KEMPS CREEK ESTATE – SSD-9522 MOD 3

Response to Request for Information

Frasers Property Industrial (**Frasers**) and Altis Property Partners (**Altis**) (referred to as the '**Frasers and Altis Kemps Creek JV**') received comments from a number of State and local authorities in response to the SSD-9522 MOD 3 Modification Report issued to DPE on 26 November 2021. The State and local authorities include:

CHECK TURNING PATHS PLAN-MOD 4 CUL-DE-SAC/BAKERS LANE
1:250 SCALE

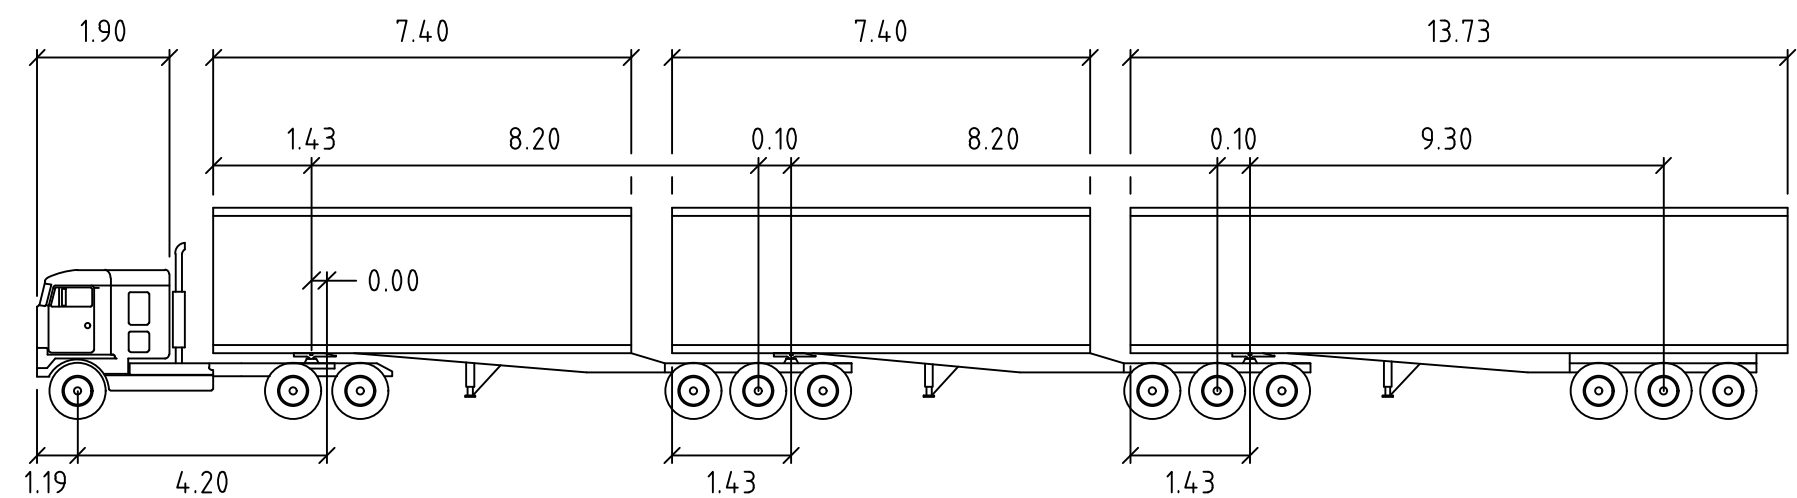
<p>As noted in the above table, the car access driveway provision complies with the requirements set out in AS2890.1:2004.</p> <p>The design of the internal roads has been addressed by Costin Roe Consulting.</p> <p>Notwithstanding, the detailed design of the proposed cul-de-sac island can be addressed separately and in response to a suitable condition of consent as part of the Construction Certification (CC) stage of this MOD.</p>				Exit: 6m	3	2	6 - 9m (comb.)	6.2m (comb.)	4	2	6 - 9m (comb.)	6.2m (comb.)	
			Exit: 6m											
3	2	6 - 9m (comb.)	6.2m (comb.)											
4	2	6 - 9m (comb.)	6.2m (comb.)											
Council recommends that Lot 3 truck swept paths (Sheet AG15) are to be modified to show that a truck can turn around while there are parked trucks.	<p>It is noted that a 26.0m B-double (if needed on a very rare occasion) will side load next to the Roller Shutter Doors (RSDs). It is important to emphasise that the tenant of Lot 3 will not require frequent movements of a B-double based on advice provided to Ason Group. Therefore, this occurrence is likely to happen infrequently.</p> <p>Furthermore, based on Ason Group's significant experience with industrial Sites, side loading of B-doubles is deemed to be normal practice and occurs within many hardstand areas of industrial developments, comparable to these warehouses. Moreover, when a B-double is side-loading, the RSDs located at the east of Lot 3 will be unoccupied to facilitate this activity, through a specific management plan and under pre-scheduled orders by the proposed tenant. Operational management measures will take place to ensure potential conflicts will be minimised as much as practically possible. Lastly, other smaller trucks entering this Lot can still use the recessed docks located towards the southern end of Lot 3.</p>	N/A												
According to Table 19 of the Transport Assessment report, Lots 1 – 4 will be accessed by trucks up to 26m B-double. However, the swept	As mentioned above, side loading of 26.0m B-doubles is deemed to be normal practice and occurs within many hardstand areas of industrial	N/A

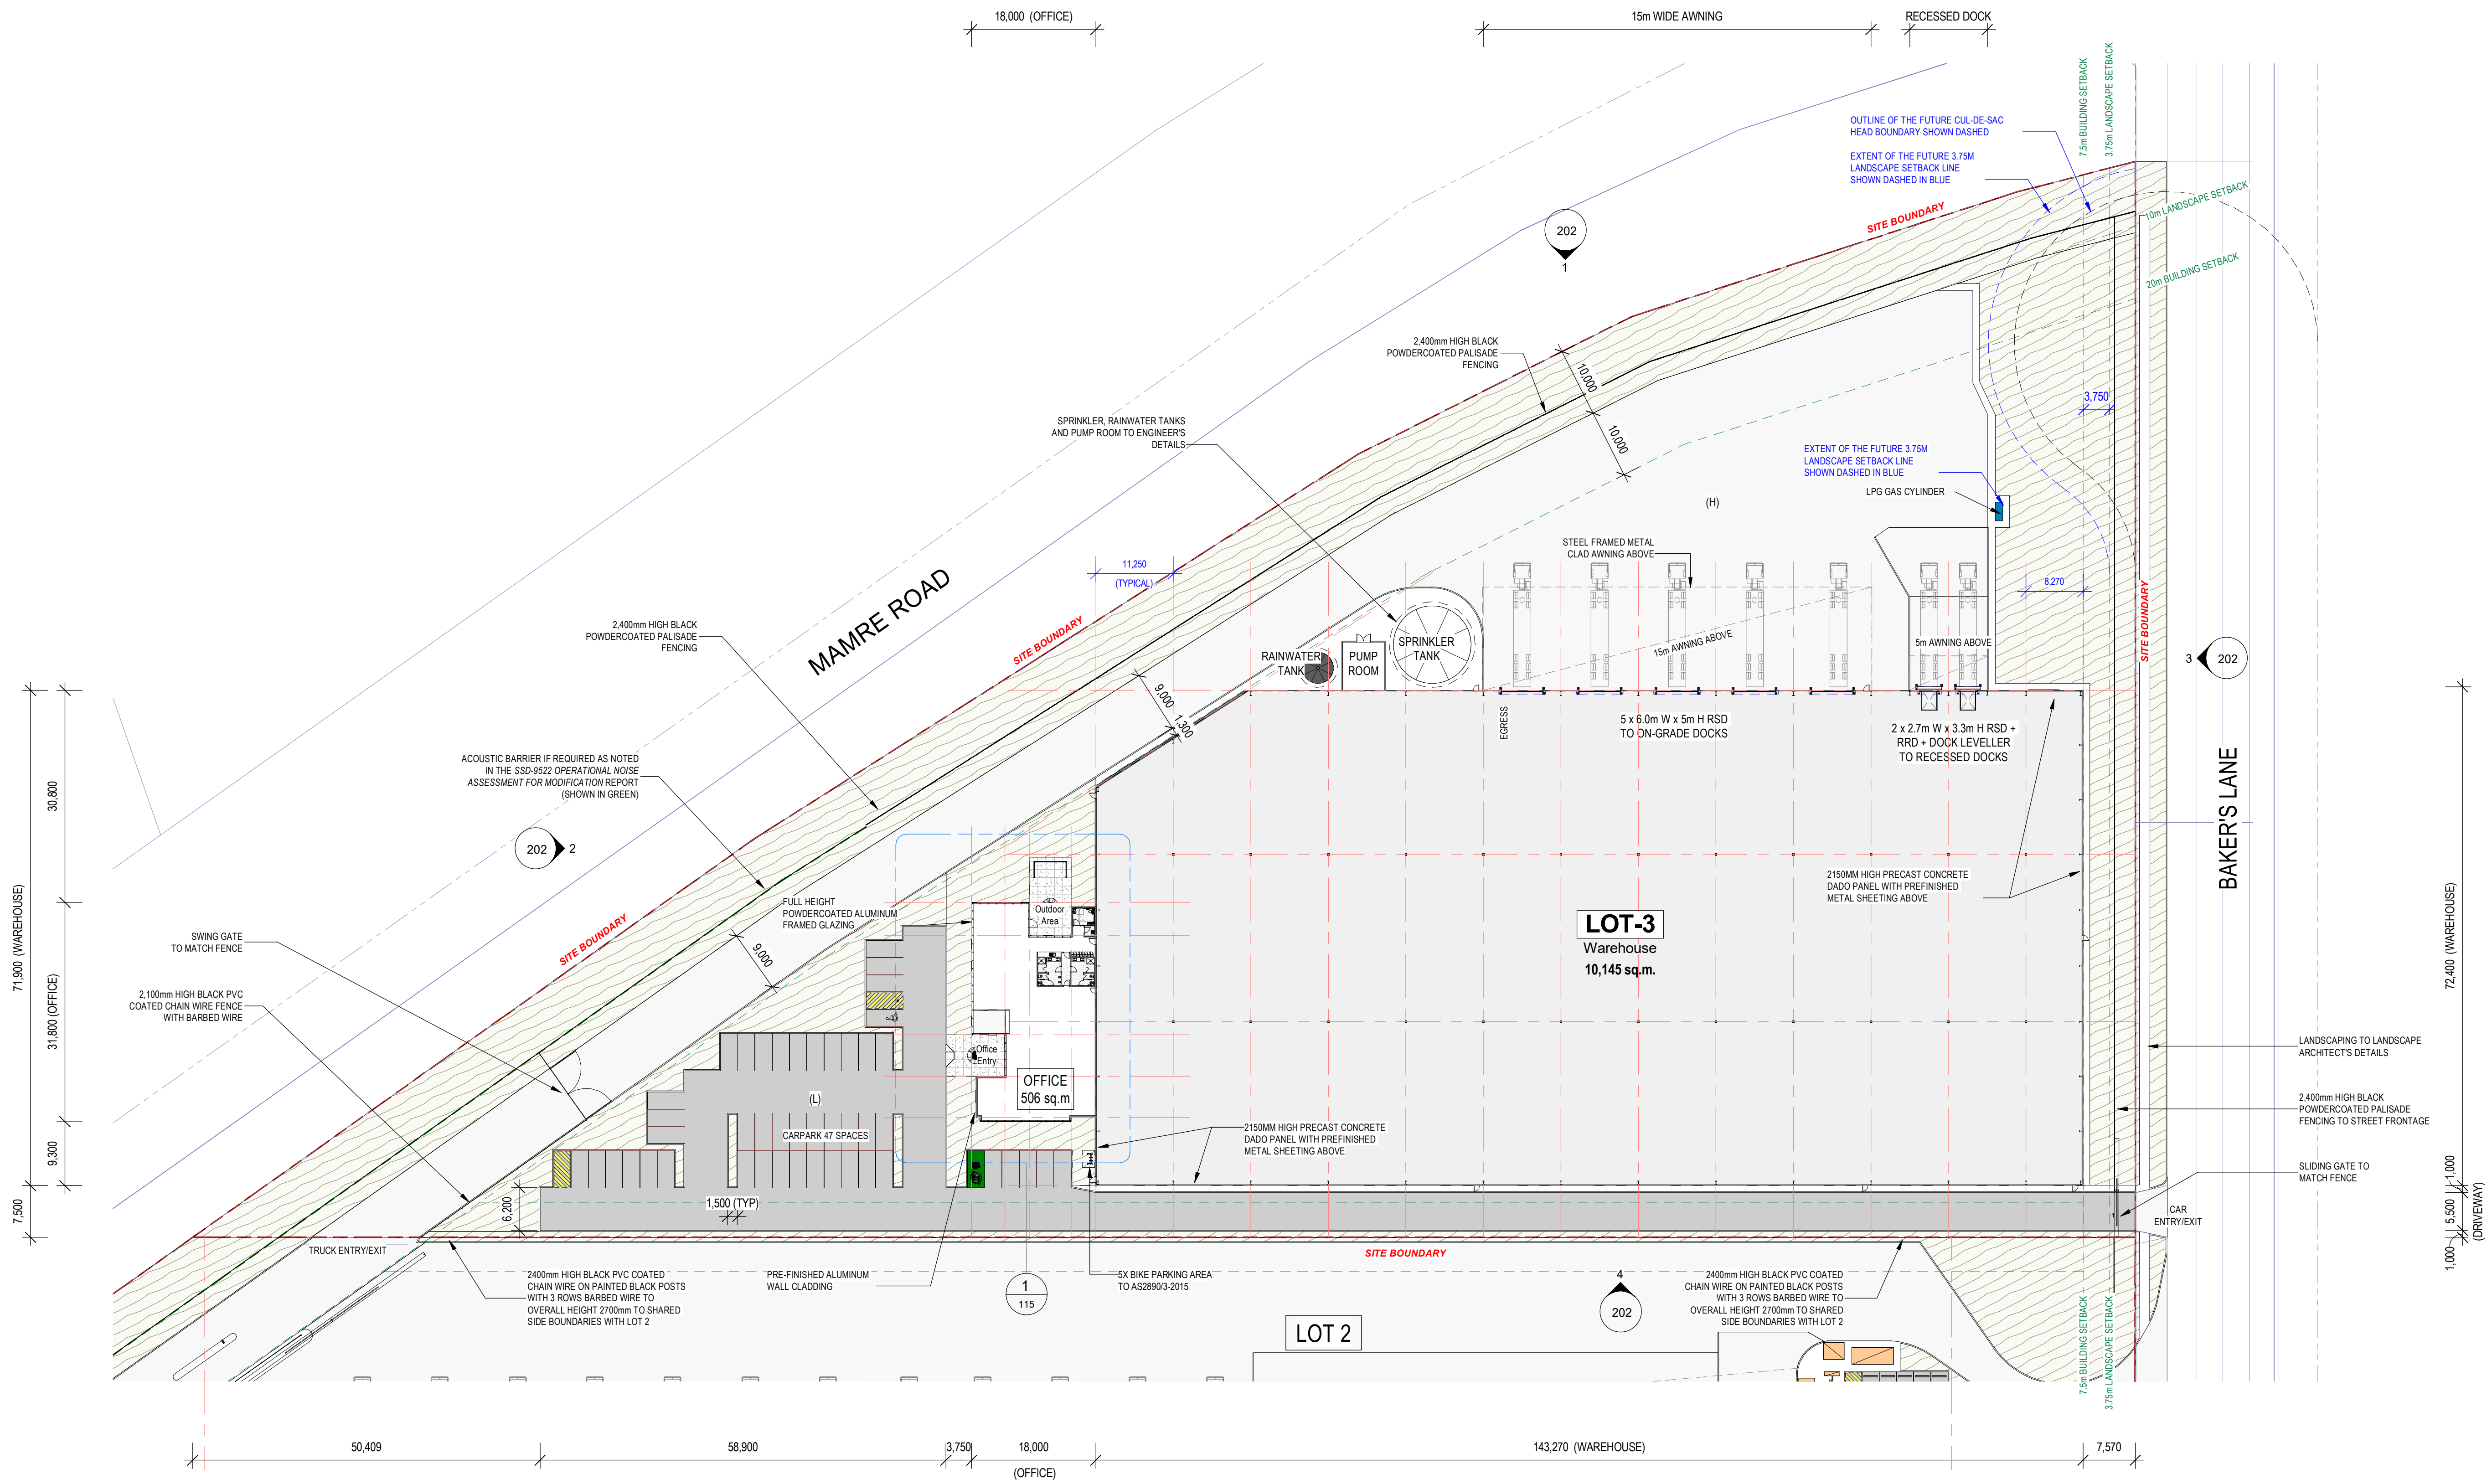
<p>The gas cylinder storage area for Warehouse 3, shown in Figure 4.5 of the SEPP 33 Assessment, should be located outside of the landscaped area.</p>	<p>The gas cylinder storage area as indicated in Figure 4.5 of the SEPP 33 Assessment has been shown on the updated Architectural Drawing and Landscape Plan for Lot 3.</p>	<p>Appendix A in this Response Table</p> <p>Appendix E in this</p>

Comment	Response	Section
	<p>The area for the gas cylinder storage areas has also been removed from the landscape area which has been recalculated.</p> <p>Lot 3 Architectural Plan:</p>  <p>Lot 3 Landscape Plan:</p> 	<p>Response Table</p>

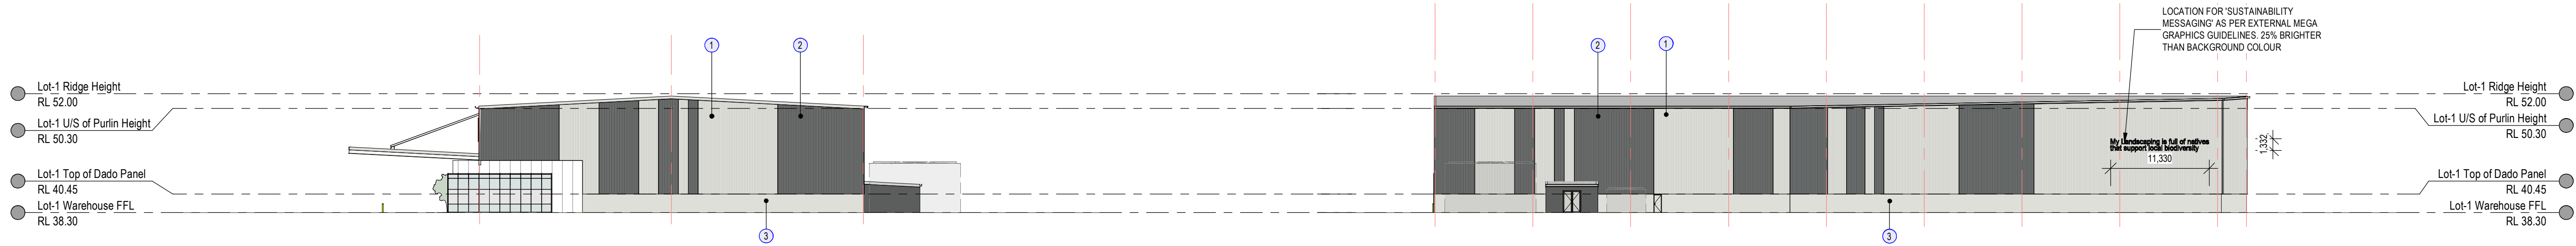
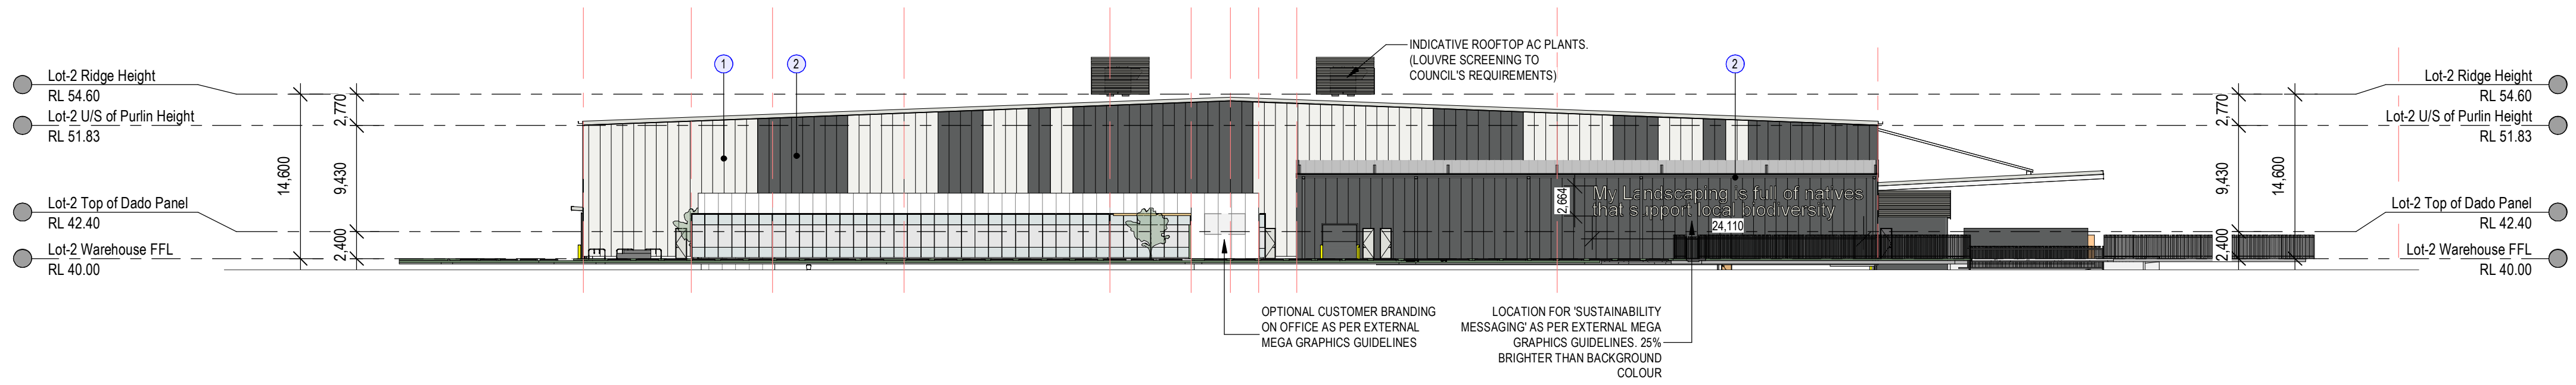
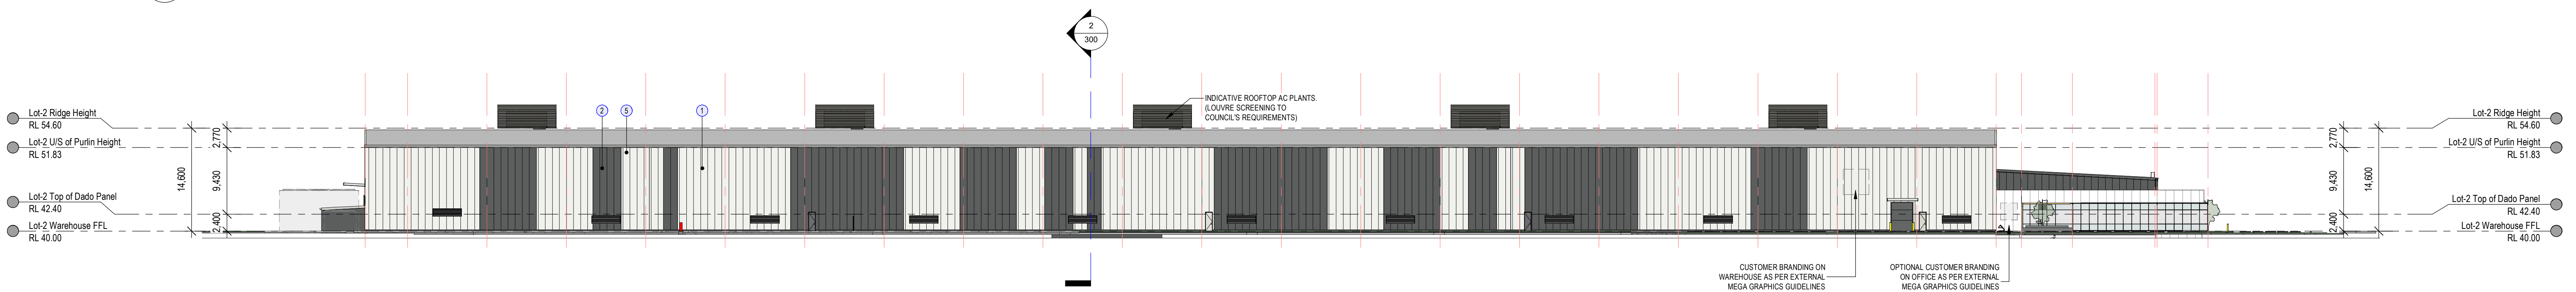
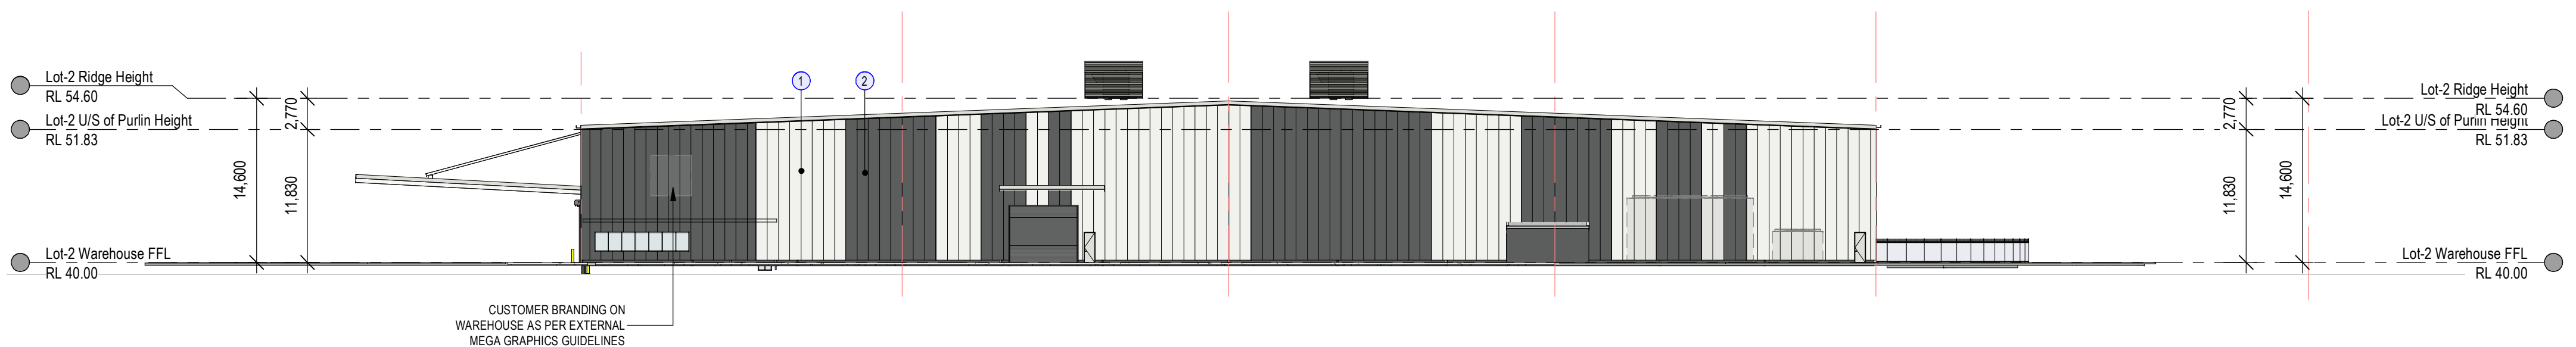
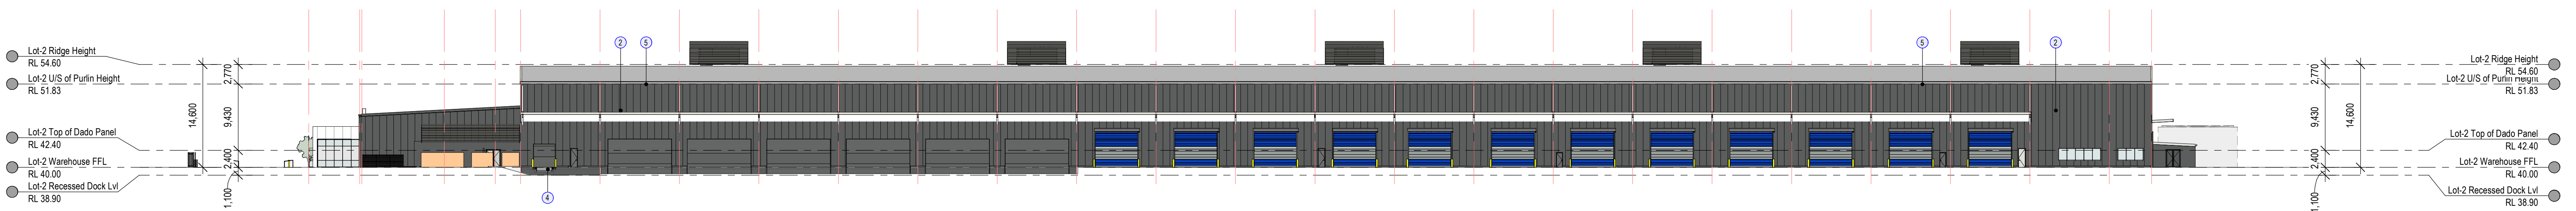
<p>The modification report states that the development will retain the same materials and finishes as approved previously. However, the external finishes identified in the architectural plans at Appendix A are different to those shown on previously approved plans for Lots 1-4. Please clarify.</p>	<p>The proposed materiality for Warehouses 1-4 as part of MOD 3 will be largely the same as what was previously approved for Lots 1-4 (Warehouses 1-3). Only the colours have been updated.</p> <p>Whilst there are more materials proposed in the original approval, the MOD 3 architectural drawings present a more simplified yet visually appealing elevation drawing.</p> <p>MOD 3 building materiality for Lots 1-4 are the same as those previously approved.</p> <p>Proposed finishes under the original approval for Lots 1-4:</p>  <p>The image contains four architectural elevation drawings of warehouse buildings. The top drawing is a side elevation showing a building with a gabled roof, featuring materials like 'PRE-FINISHED METAL WALL CLADDING', 'PAINTED FULL HEIGHT PRECAST WALL PANEL', and 'PAINTED ALUMINUM BUTTRESS'. The second drawing is another side elevation showing 'PRE-FINISHED METAL WALL CLADDING', 'PAINTED FULL HEIGHT PRECAST WALL PANEL', and 'PAINTED ALUMINUM BUTTRESS'. The third drawing is a front elevation showing 'PRE-FINISHED METAL WALL CLADDING', 'PAINTED FULL HEIGHT PRECAST WALL PANEL', and 'PAINTED ALUMINUM BUTTRESS'. The bottom drawing is a front elevation showing 'PRE-FINISHED METAL WALL CLADDING', 'PAINTED FULL HEIGHT PRECAST WALL PANEL', and 'PAINTED ALUMINUM BUTTRESS'.</p>	<p>Appendix A in this Response Table</p>
